Mrs Sarah Dand

Conversion of buildings to create nine dwellings (Use Class C3) and associated works, including demolition of existing extensions, alterations to exterior and formation of first floor.

St Barnabas Church, Old Mill Lane, Barnsley, S71 1PN

ELEVATION 5

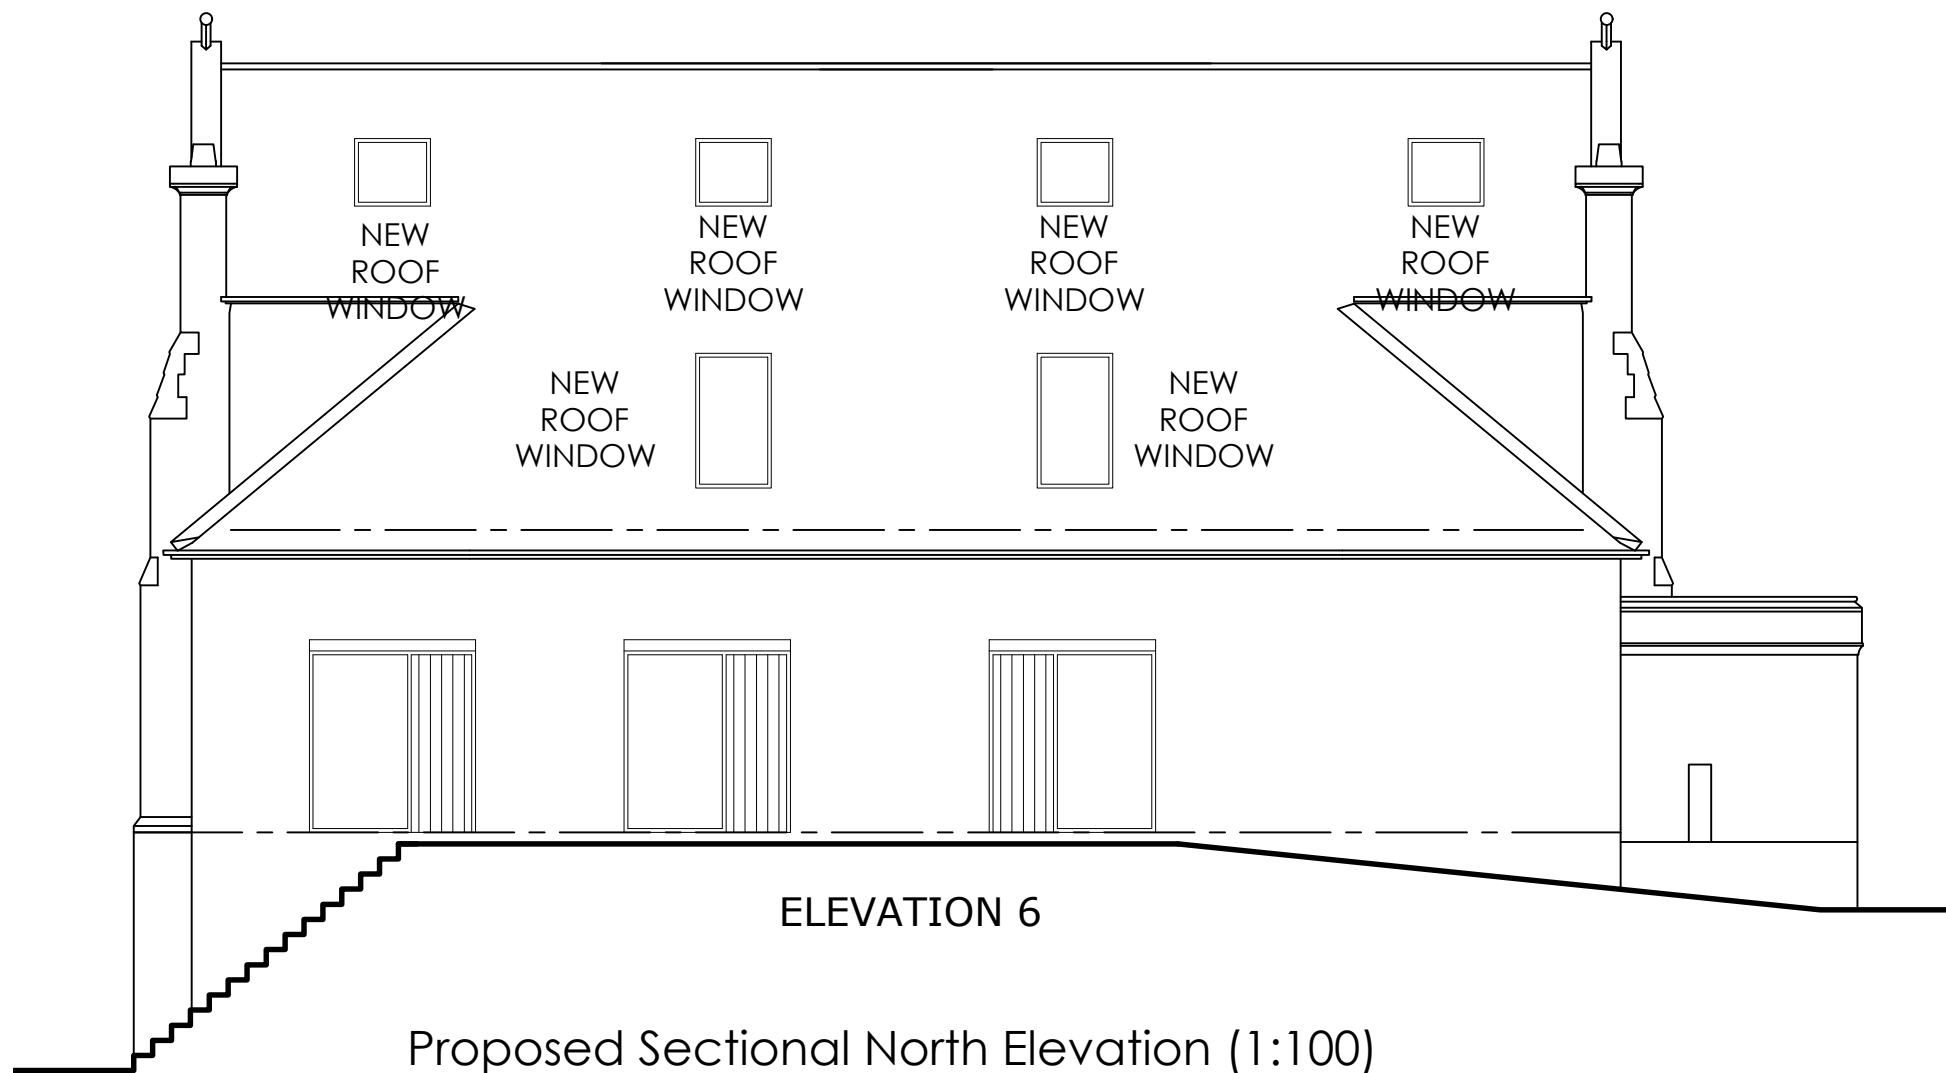
As described above, the majority of the new window openings are at ground floor and roof level and therefore would not cause direct overlooking of neighbouring properties. However, the LPA did raise concerns that overlooking from Flat 9's first floor bedroom could occur upon residents of Nos. 51 and 53 Bridge Street. This is due to the separation distance between the rear elevation of those properties and the western elevation of church being only 18.1m, thus below the SPD requirement. Whilst, the existing large trees and small garden outbuildings do provide some screening, the proposal has been amended to ensure that the existing large gable end windows are obscure glazed to prevent overlooking.

Typically, main habitable room windows (such as bedrooms) are not obscure glazed to ensure adequate levels of natural light. However, given that the bedroom will also be served by the proposed rooflights, the installation of obscure glazing is considered to be acceptable. To protect amenity further, the eastern facing gable windows (which would serve Flat 6's bedroom) will also be obscure glazed for the same reasons. The proposed plans have been updated to reflect this and a condition attached.
